2 August 2018

APPLICATION NO: SSD 8989 (Our Ref. 25-2018-4-1)
PROPOSAL: Catherine McAuley Catholic College
PROPERTY: 507 Medowie Road MEDOWIE, 2 Kingfisher Close MEDOWIE
(LOT: 412 DP: 1063902, LOT: 413 DP: 1063902)

Thank you for your correspondence dated 2 July 2018 requesting Council's comments for the above development. Council has given consideration to the likely impacts of the proposal and makes the following comments.

Landscape Plan

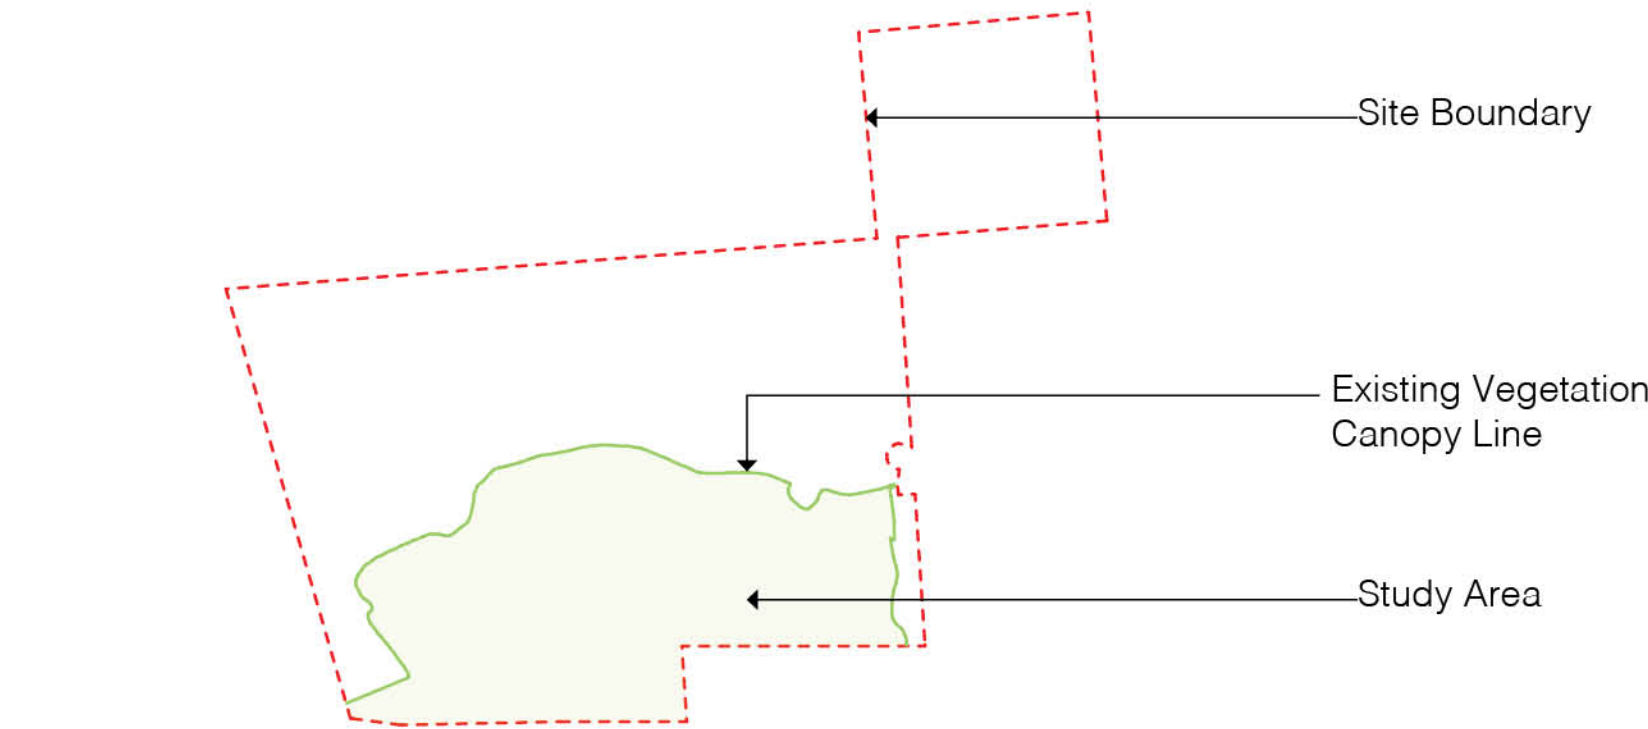
- e. A 10 metre fully revegetated buffer should be maintained along the waterway traversing the southern section of the subject land and the management of the riparian buffer should be consistent with the *Controlled activities on waterfront land – guidelines for riparian corridors on waterfront land* prepared by the NSW Office of Water and dated 2012;
